Date: 31st October 2019  
Our Ref: 19/02650/PREAPP  
Please ask for: Chloe Jacobs  
Telephone: 01993 861697  
Email: [chloe.jacobs@westoxon.gov.uk](mailto:chloe.jacobs@westoxon.gov.uk)

APPLICATION: 19/02650/PREAPP

PROPOSAL: Alterations to include demolition, conversion and replacement of various outbuildings

AT: Dower House Dunthorp Road Heythrop

PLANNING			
TITLE	POOL HOUSE, Elevations & Section AA as proposed		
PROJECT	Dower House Master Plan, Heythrop, OX7 5TL		
JOB NUMBER	DRAWING NUMBER	REVISION	DATE
815	(PL) 09	X	04.10.2021
SCALE	DRAWN	CHECKED	
1:50 @ A1	AM	CB

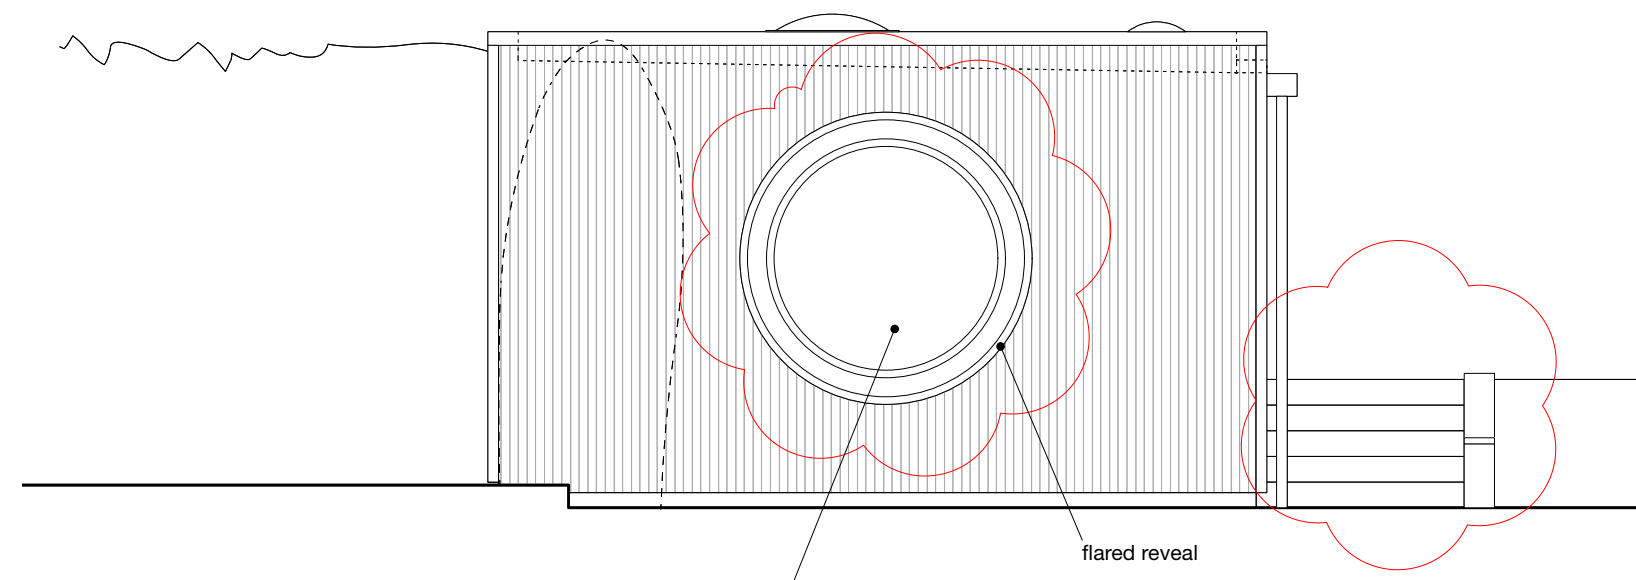
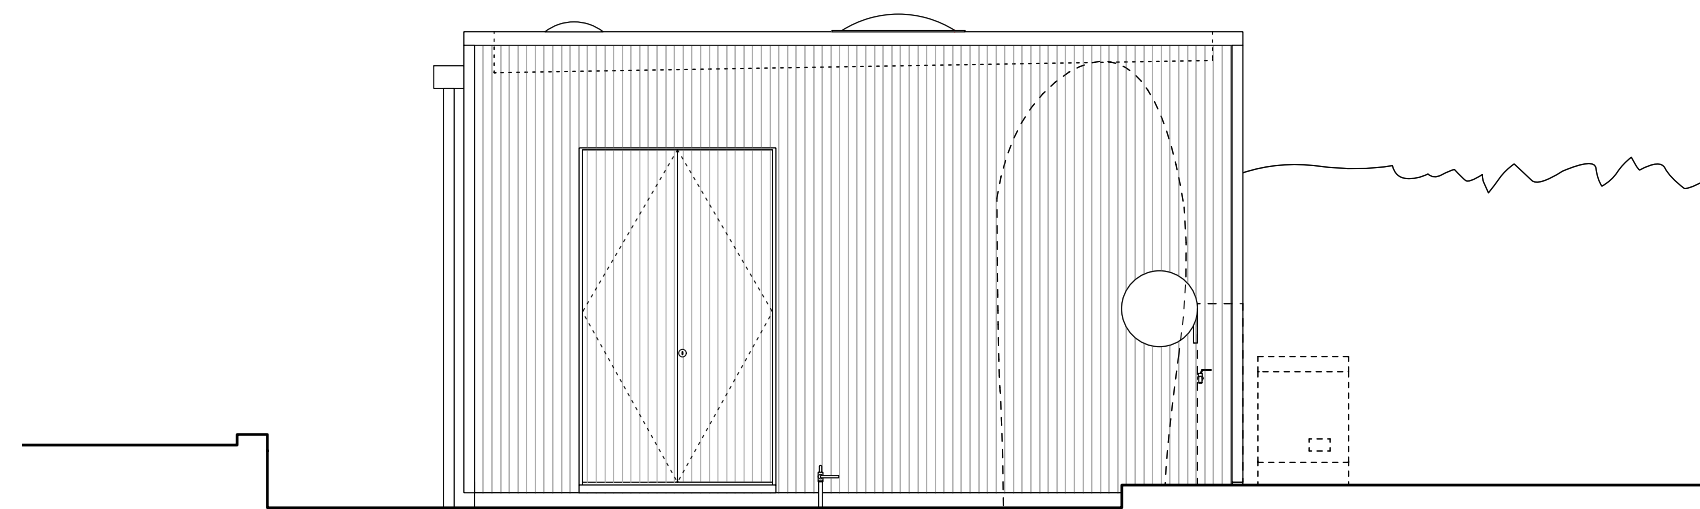
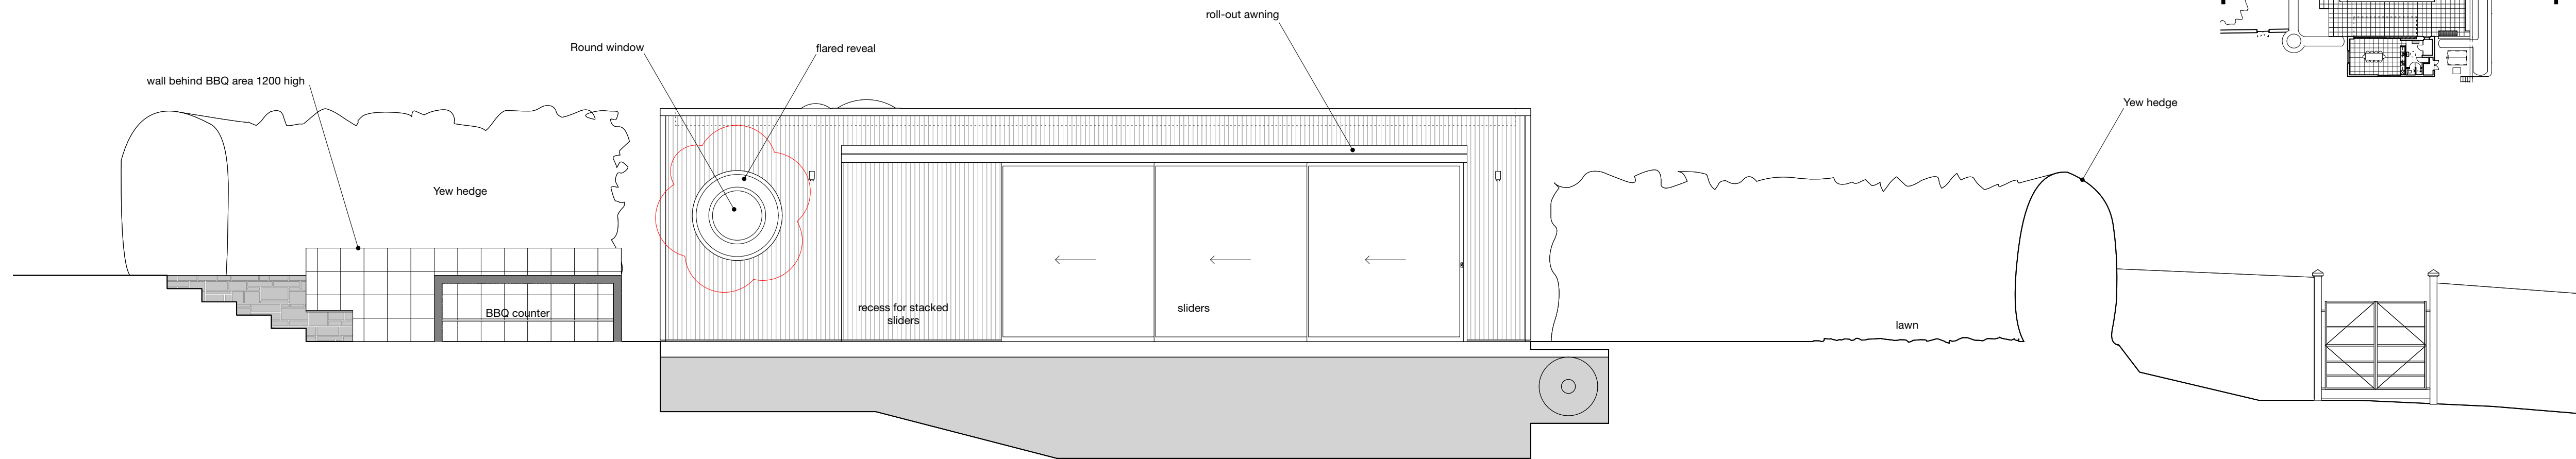
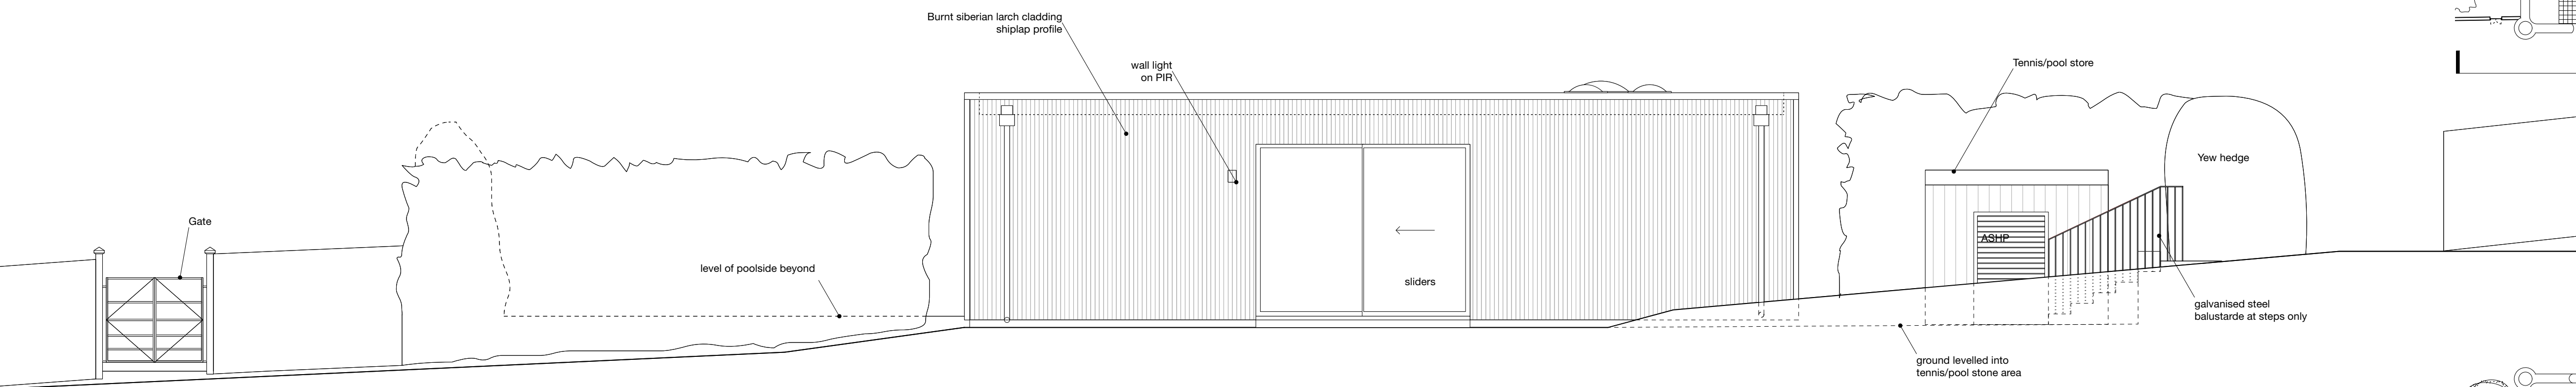
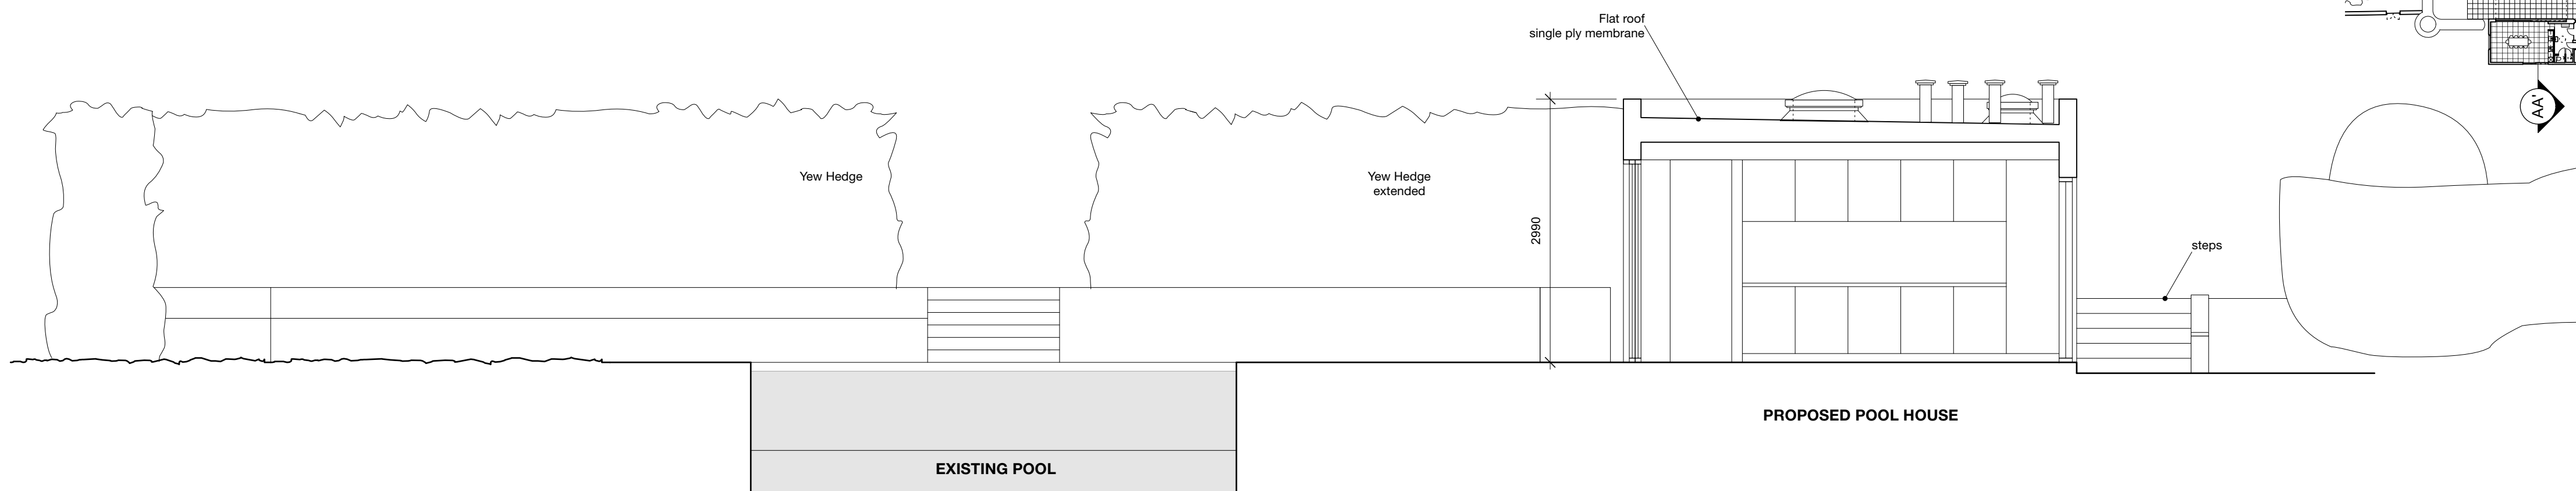
The proposed pool house is a sizeable building which ultimately spreads the development a considerable distance away from the main dwellinghouse. This element would need to be significantly reduced by at least a third of its proposed size. We would therefore suggest that the floor plan is minimal and that the structure is as low as possible to protect views both into and out of the setting of the nearby Grade II Listed building. A low pitched, standing seam zinc roof might allow for the building to sit lower within the landscape.

PLANNING			
TITLE OUTBUILDINGS, Elevations & Sections 01 as proposed			
PROJECT Dower House Master Plan, Haythrop, OX7 5TL			
JOB NUMBER	DRAWING NUMBER	REVISION	DATE
815	(PL) 04	X	04.10.2021
SCALE	DRAWN	CHECKED	
1:50 @ A1	AM	CB

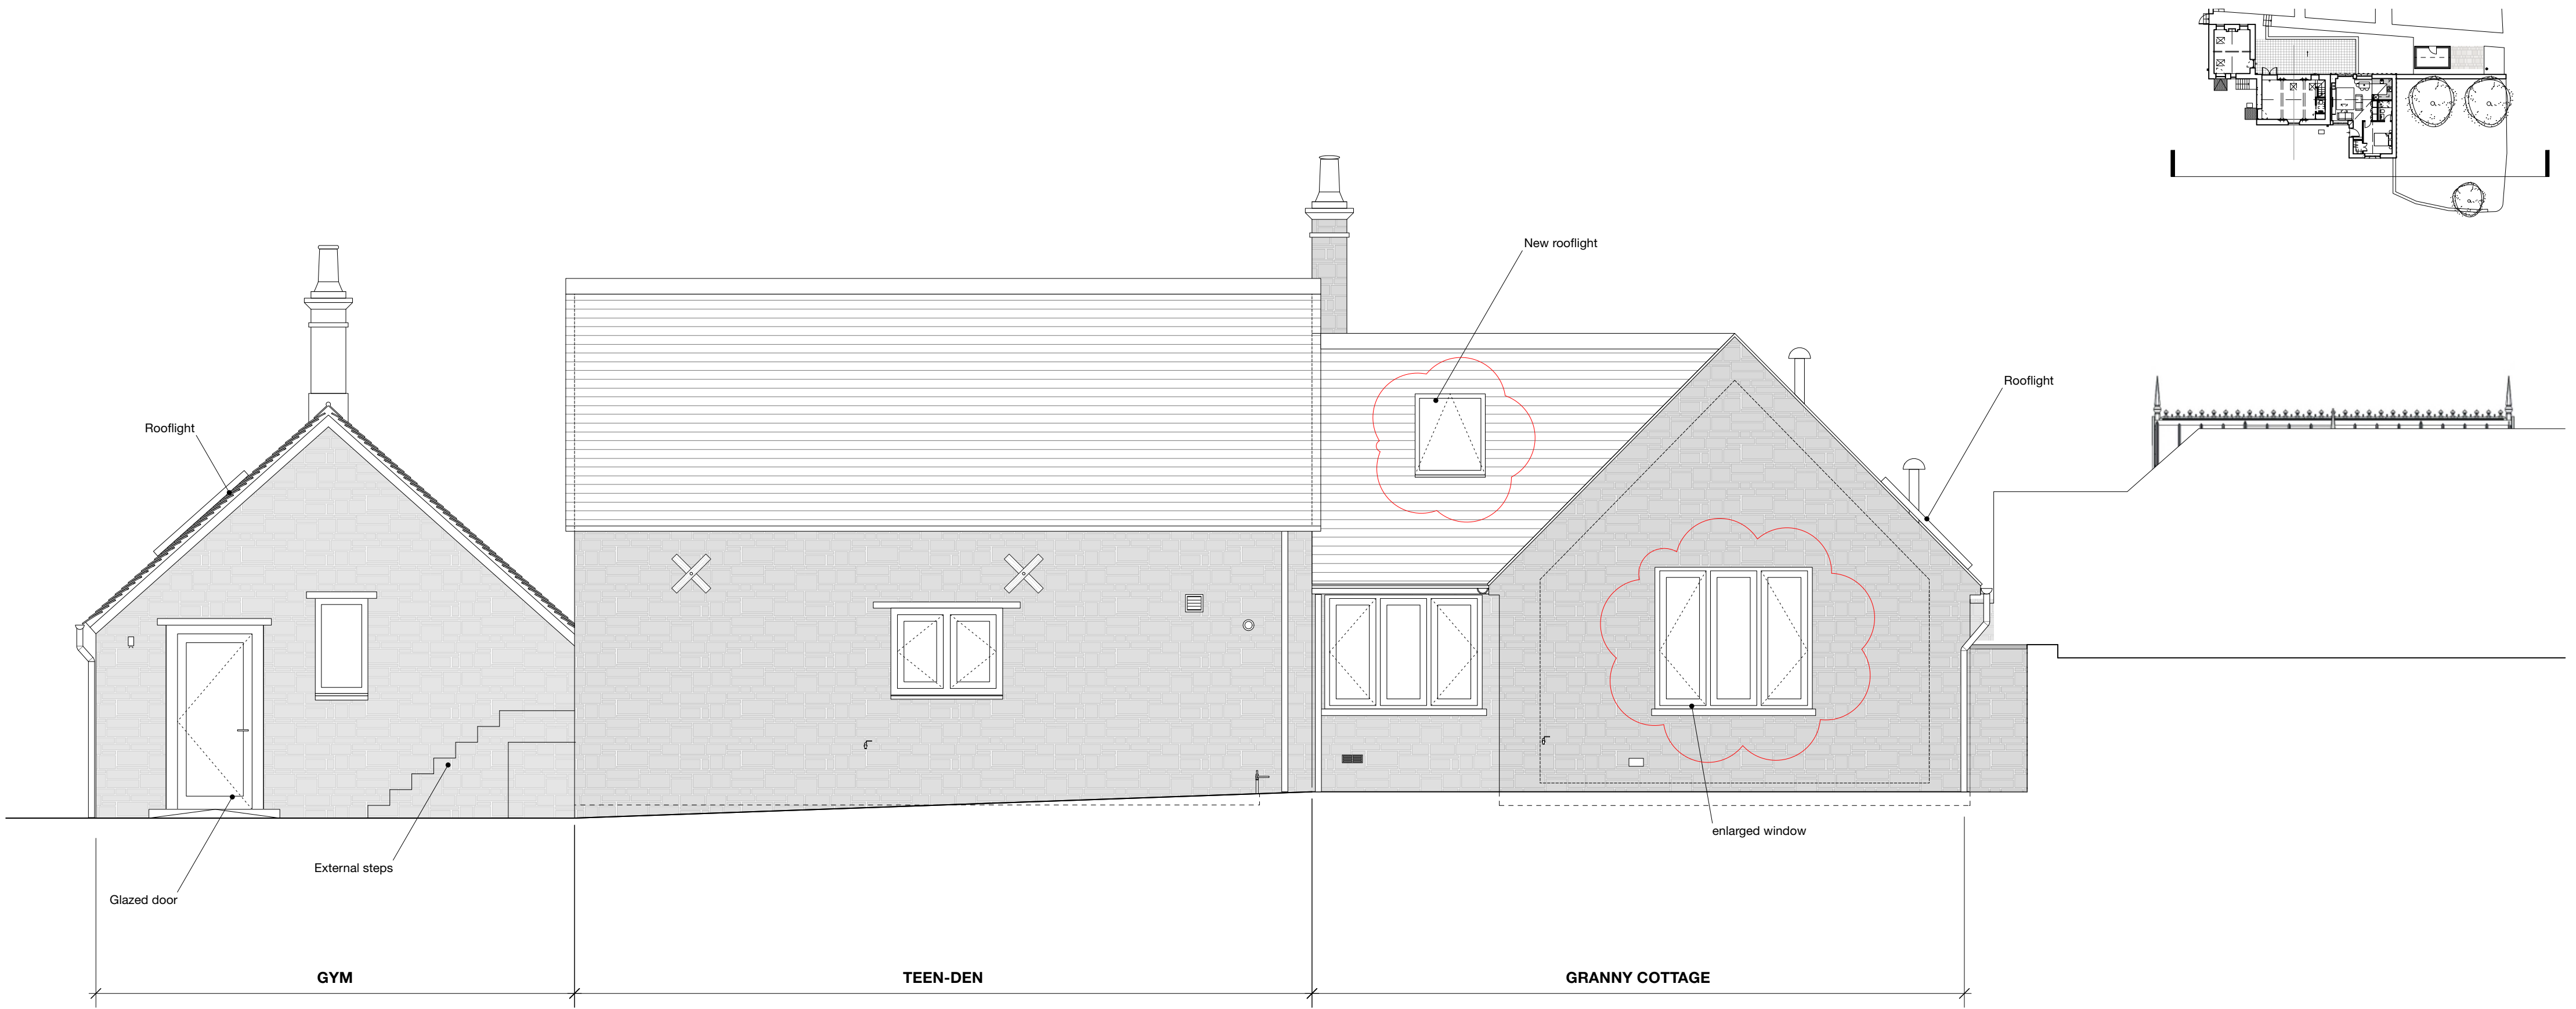
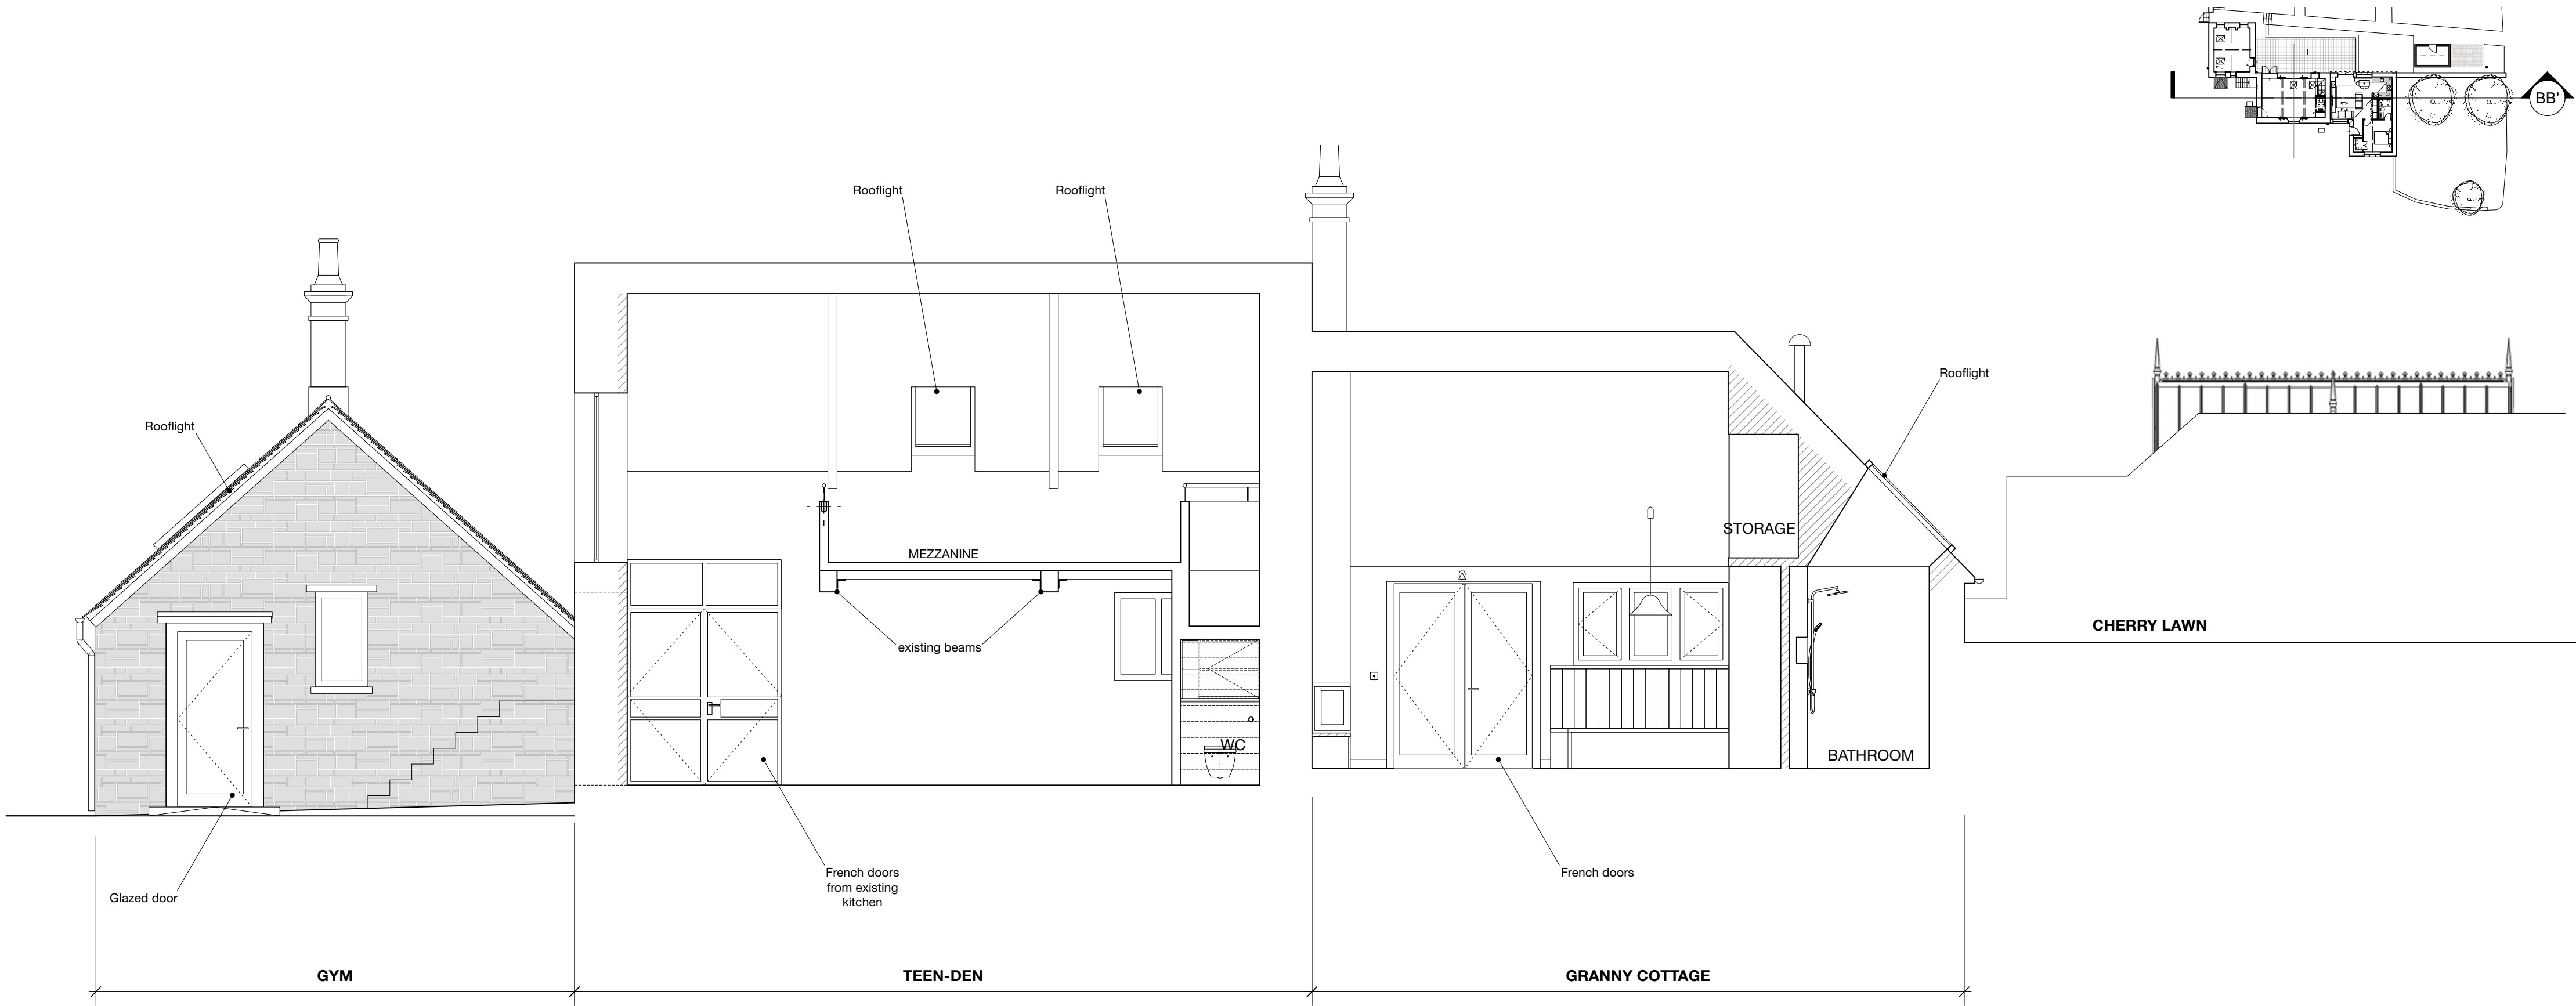
The conversion of the existing outbuildings to new uses that are ancillary to the main dwellinghouse is considered to be acceptable in principle. If a formal application is submitted, officers may find it necessary to apply a condition to the consent tying these outbuildings to the Dower House so that they remain ancillary. The extension to the proposed studio is also considered to be acceptable in principle. However we would suggest reducing the number of rooflights to create a nice, simple and uncluttered roof space.
